From: Andrew Wood
Sent: 14 March 2019 10:44
To: Karen Parsons
Subject: FW: Planning Application FG/220/18/PL : Land adjacent to Elm Lodge, Tamarisk Way, Ferring, West Sussex BN12 5ER
Attachments: Re_Planning Application FG_220_18_PL _ Land adjacent to Elm Lodge, Tamarisk Way, Ferring, West Sussex BN12 5ER.eml

Further to Laura Gibbons' out of office email message below, we have been in discussions with Laura regarding the above application and agreed an extension of time with Andrew Wood until 8th March 2019 to enable us to address Laura's objection regarding the impact of the proposed detached chalet-style dwelling on the existing pond. I have forwarded our correspondence below for your information.

In order for me to remove my objection I am going to need some further information to be supplied:

PROPOSED INDICATIVE PART
FOUNDATION SECTION DETAIL 1:50.

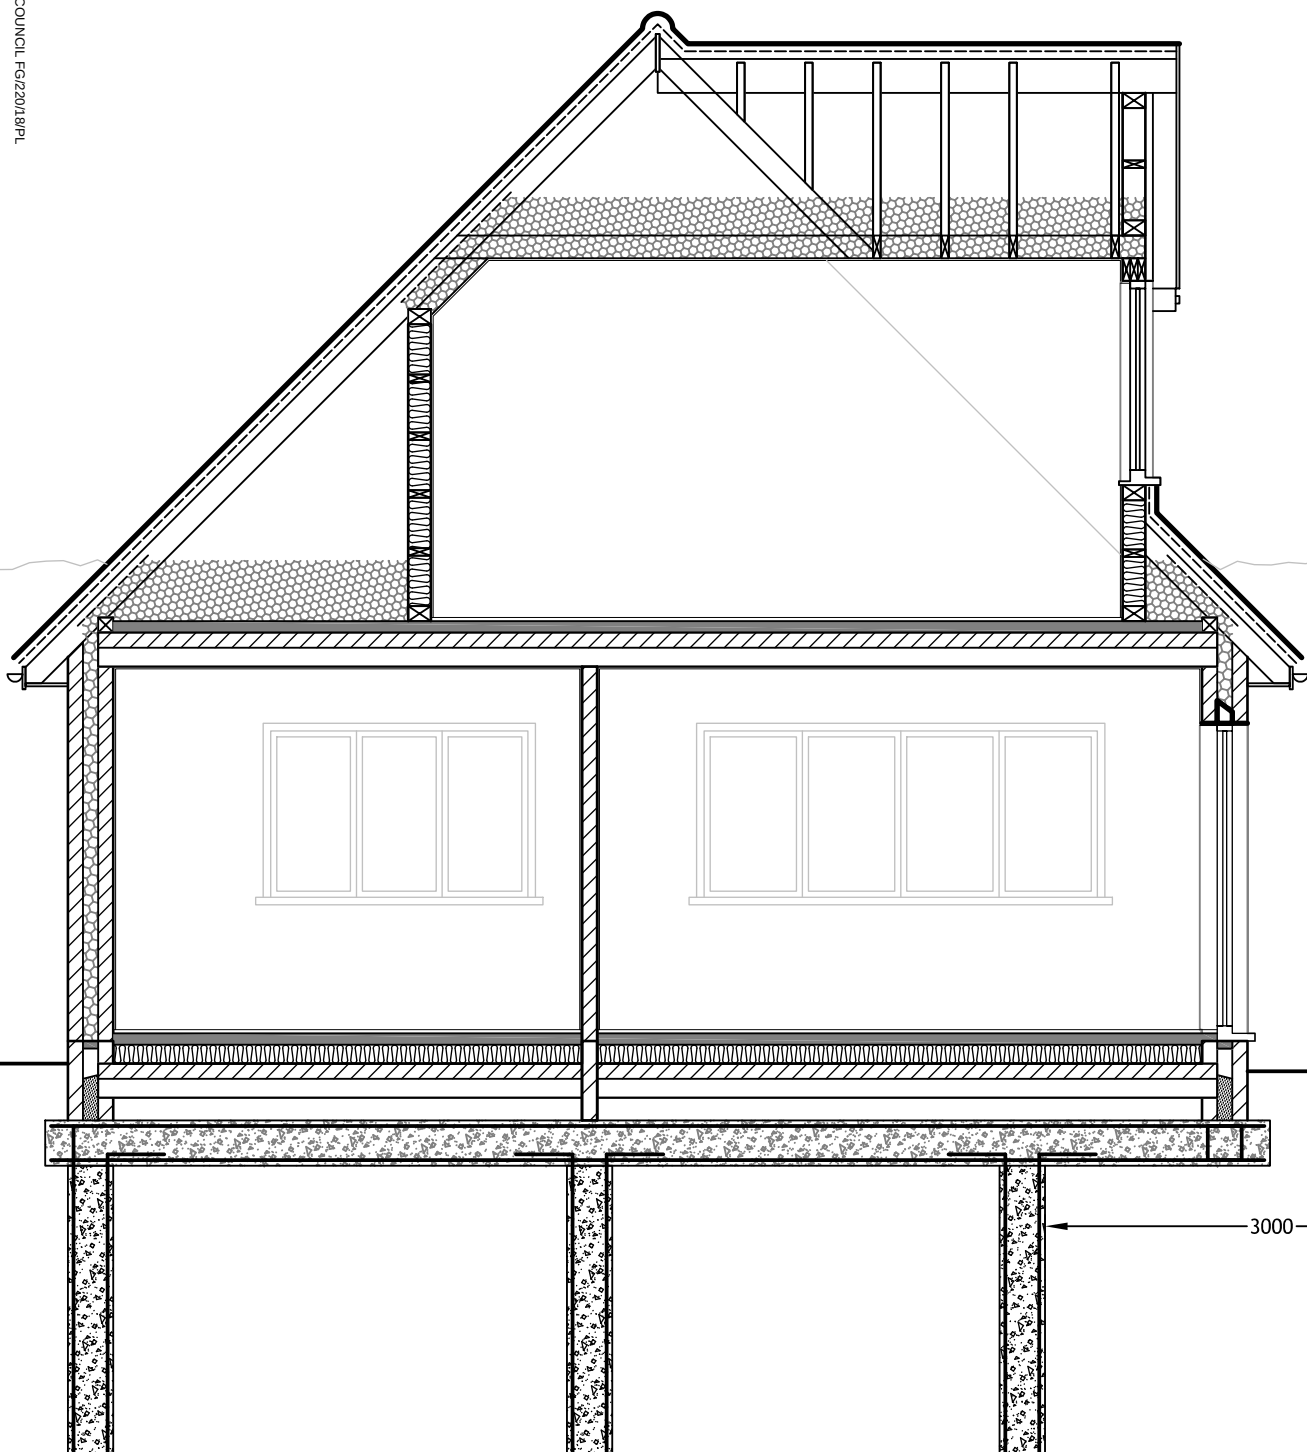
2. I am not keen to see the building go up to within 0.8m of the pond. Access and erosion are both a concern. I would therefore be keen to see the building layout revised to provide more easement. As shown on the proposed indicative part foundation section detail, short bore piles would be positioned a minimum of 3m from any edge of the pond, reducing the risk of erosion by eliminating trench foundations. Given a specialist would be designing the reinforcement/camp shedding for the existing edge of the pond (again, to be agreed with ADC by condition prior to commencement), this would ensure there will be no erosion. Given the building would only be cantilevered at one point within 0.8m of the pond, there is still a large area of access

We also attach an indicative proposed part foundation section detail to show proposed short bore piles a minimum of 3m from the edge of the existing pond. There will be no encroachment or structural implications for the pond.
